10th December 2020

**Objections to the planning application for the
erection of detached dwelling with integral garage
at Springwood House, Sheffield Road, New Mill HD9 7EX**

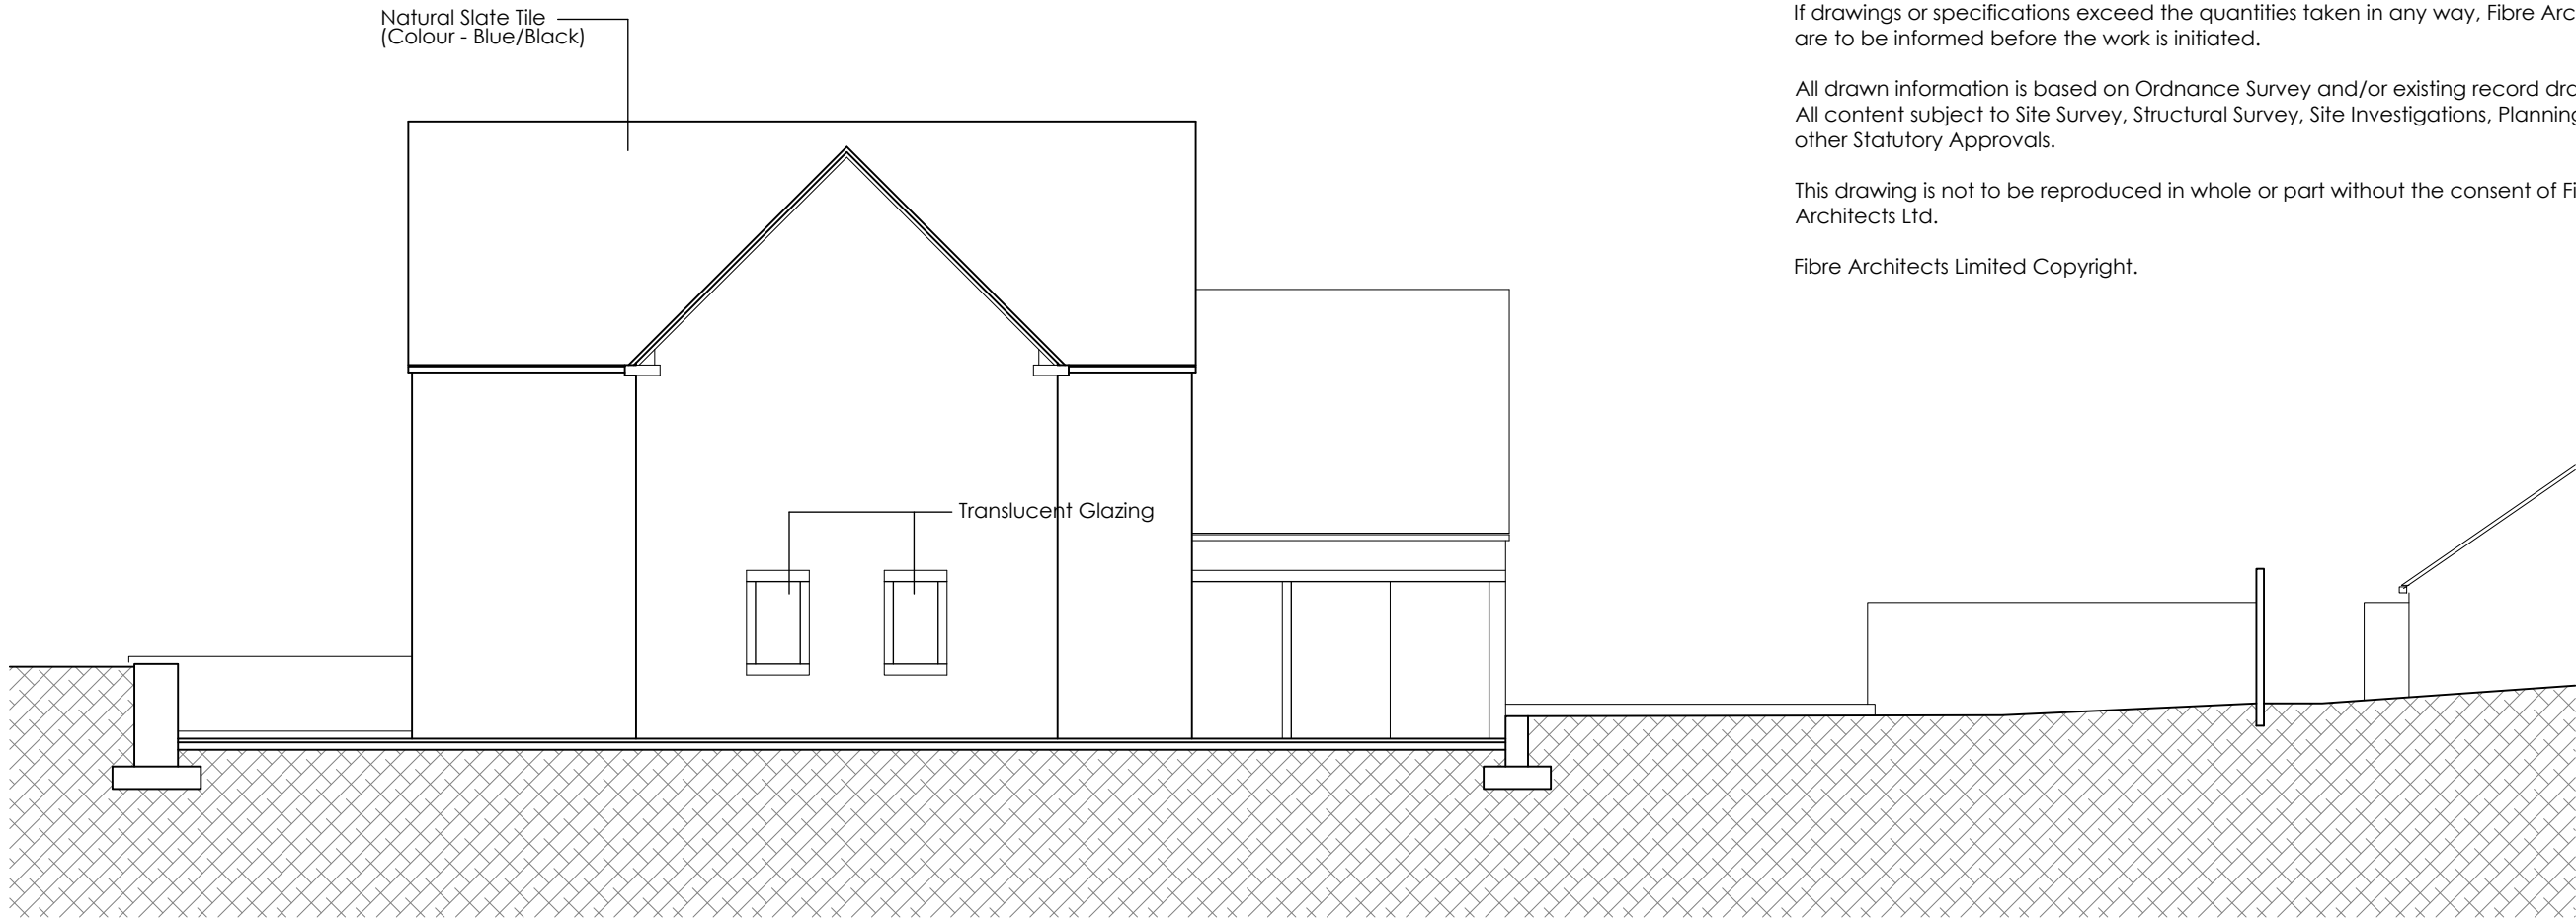
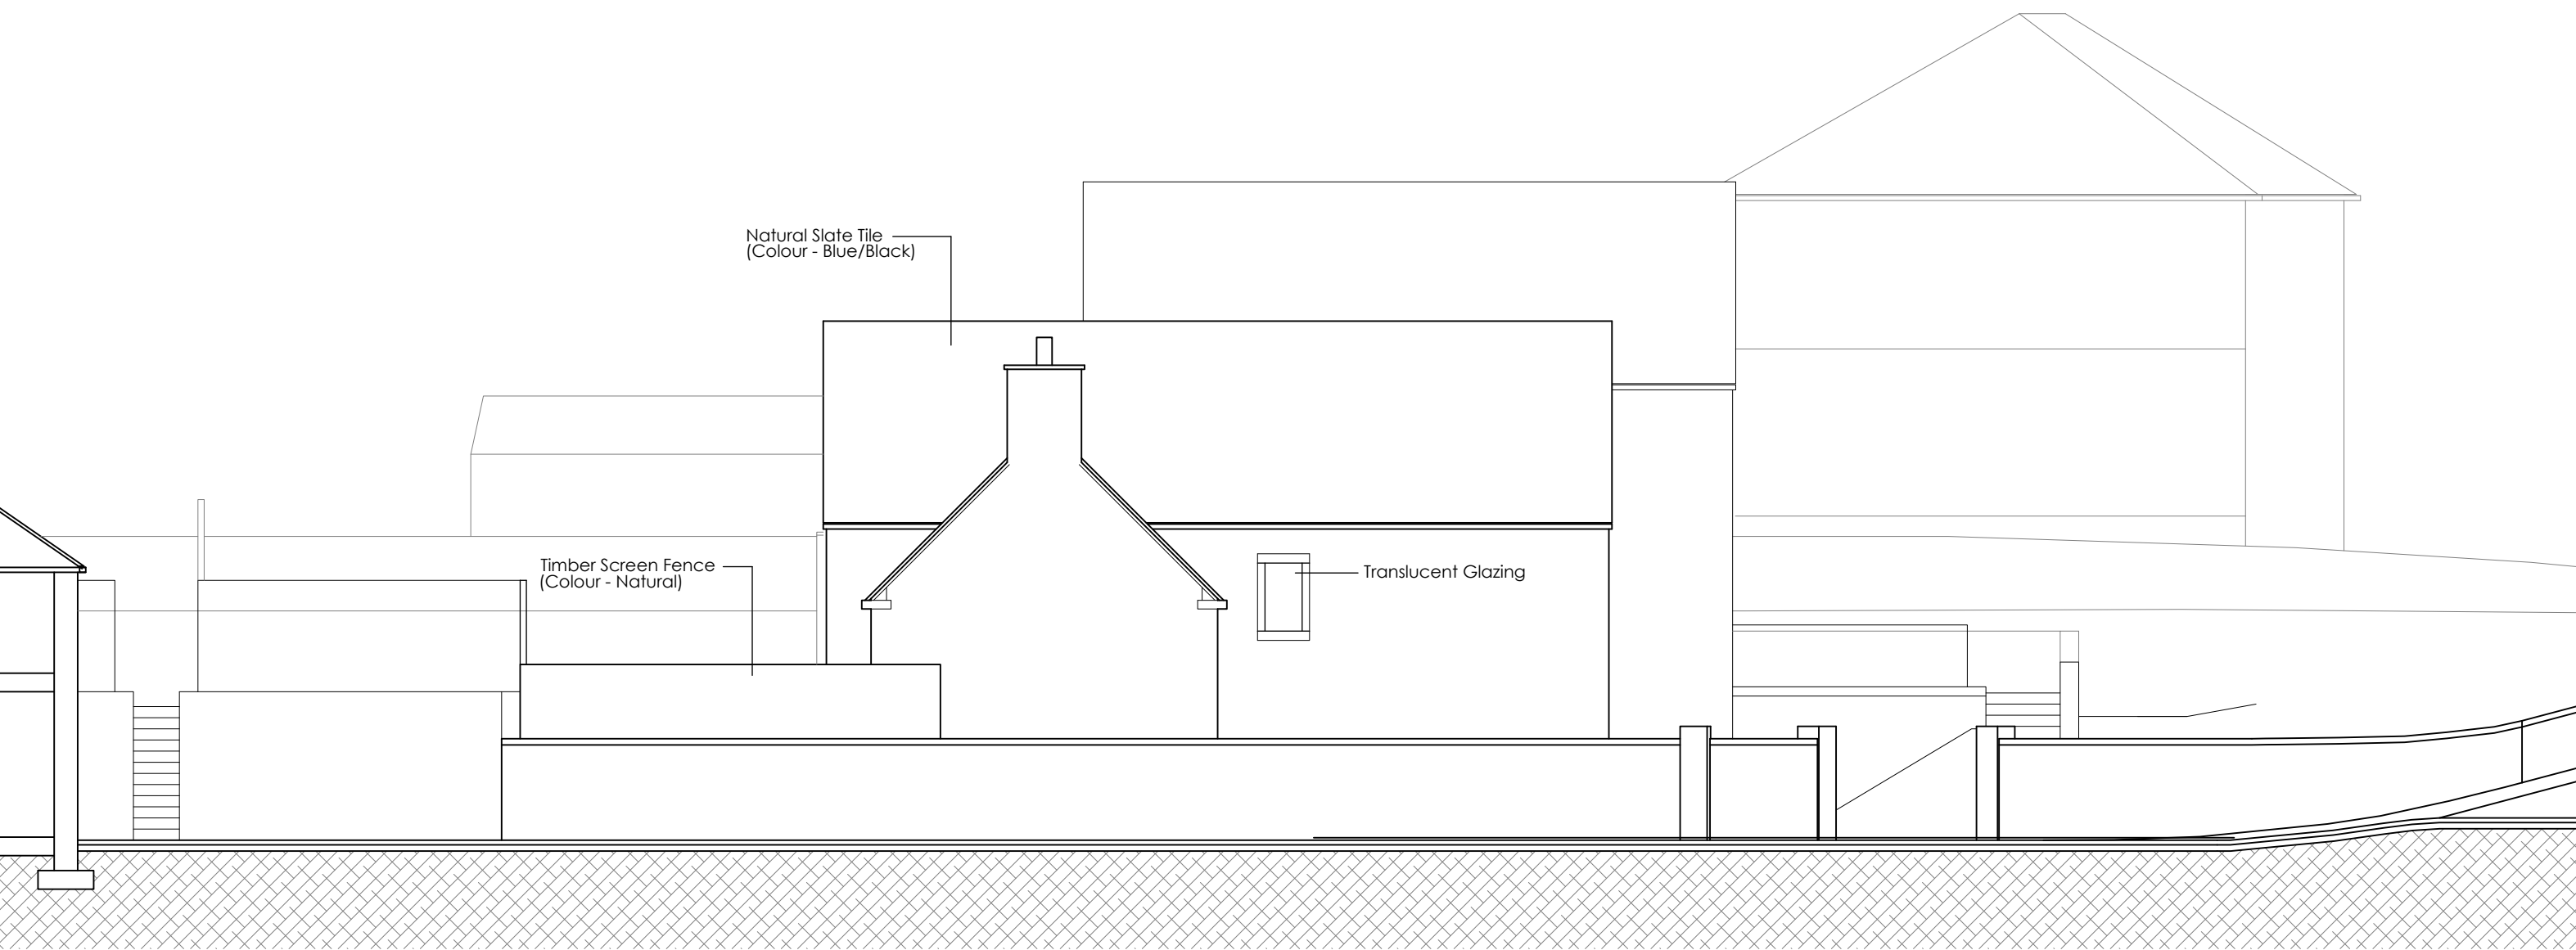
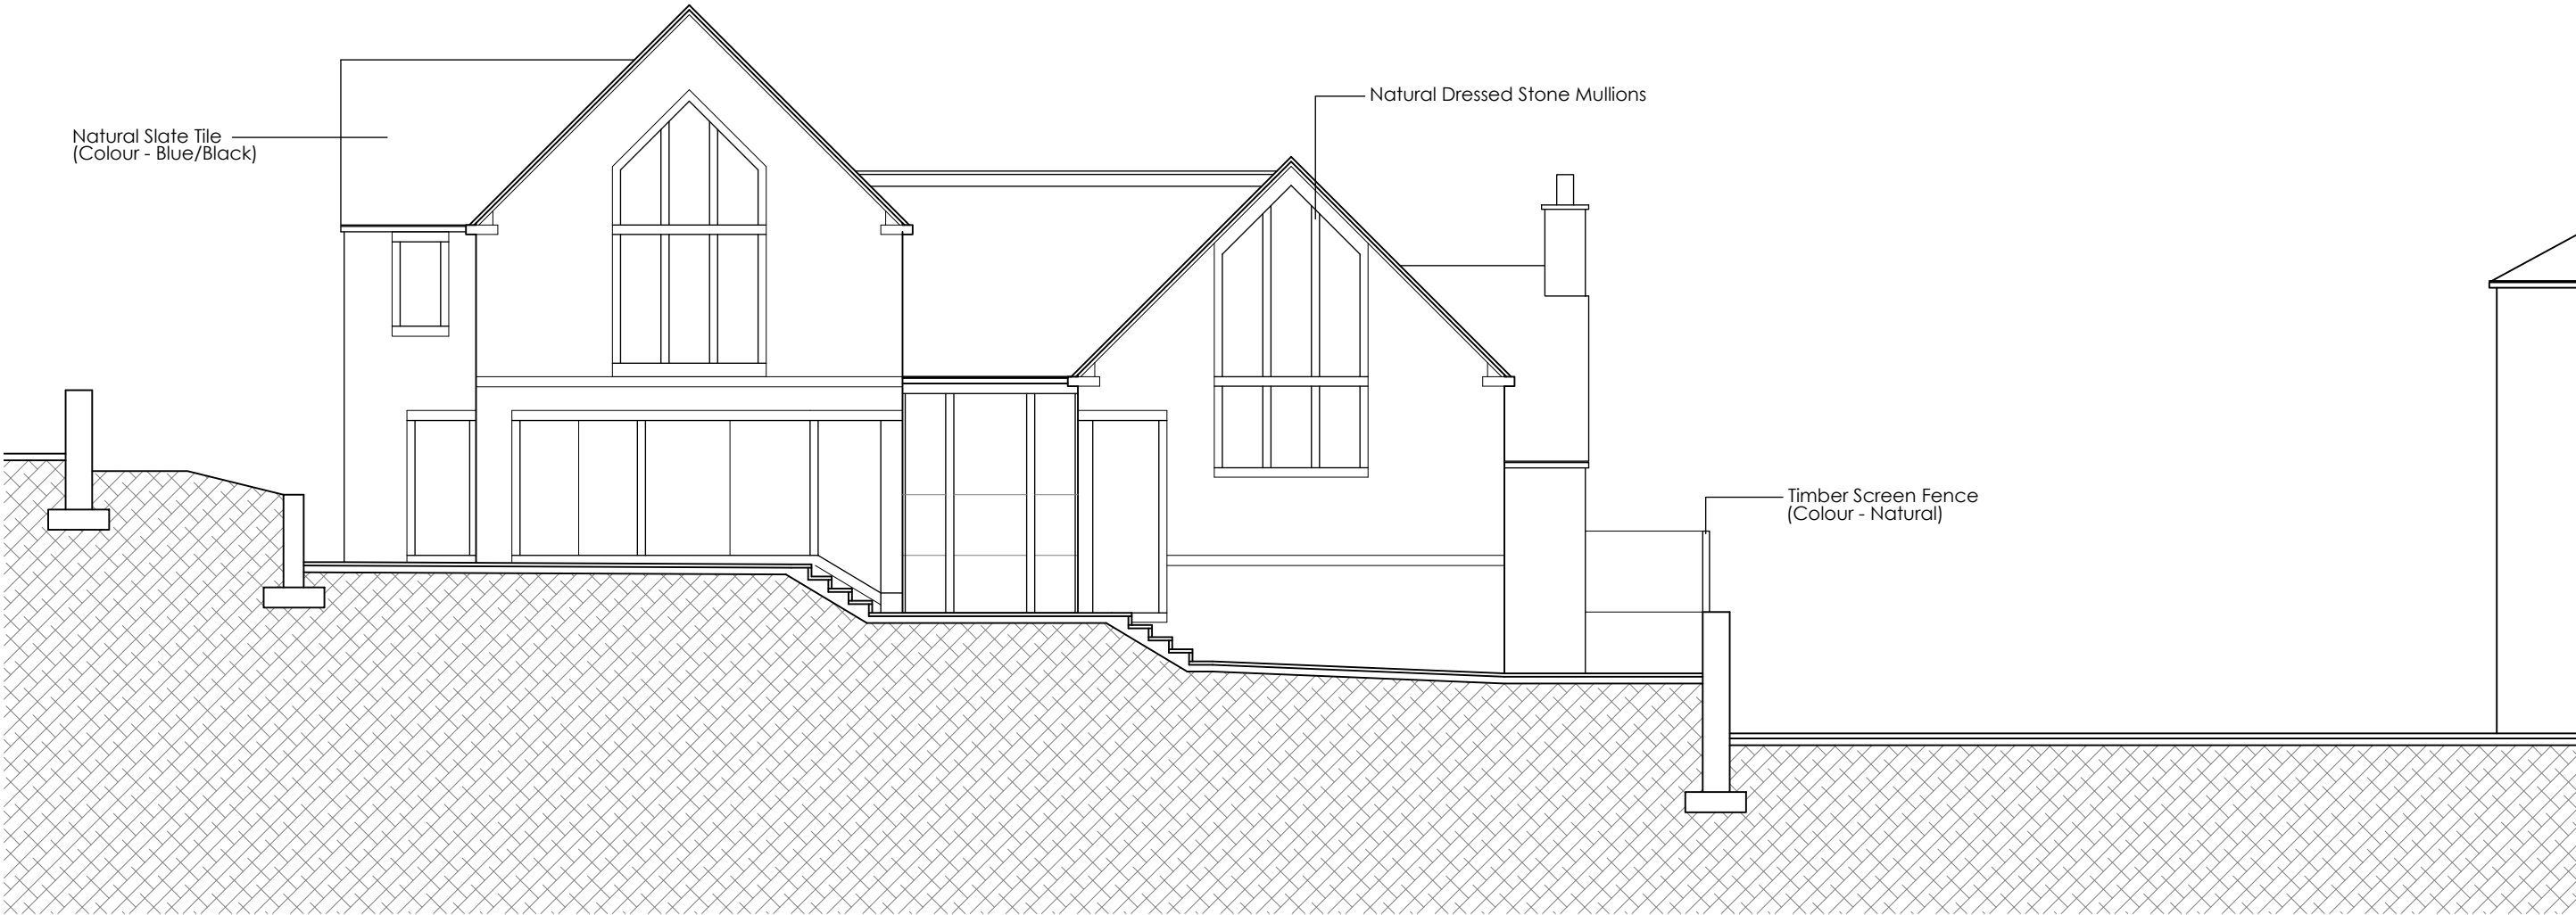
4. CHARACTER OF THE NEW BUILD
Springwood House and The Coach House share a history and the new house will sit in close proximity (around 6 8 meters) to both. Therefore it would be best if it were to look like it fit in. The style of the plans are for a 3 story house with large arched windows and lots of levels, will in my opinion, overpower, dominate and distract from what is a lovely, simple, period setting.

5. HEIGHT OF THE NEW BUILD
I am concerned that the height of the new build will block the sun from the front of The Coach House, which as I've stated is where 90% of my windows are. Trees block sun to the East and Springwood House to the West, so I think this could have a significant effect on the light levels in my home. And also from my garden and vegetable patch.
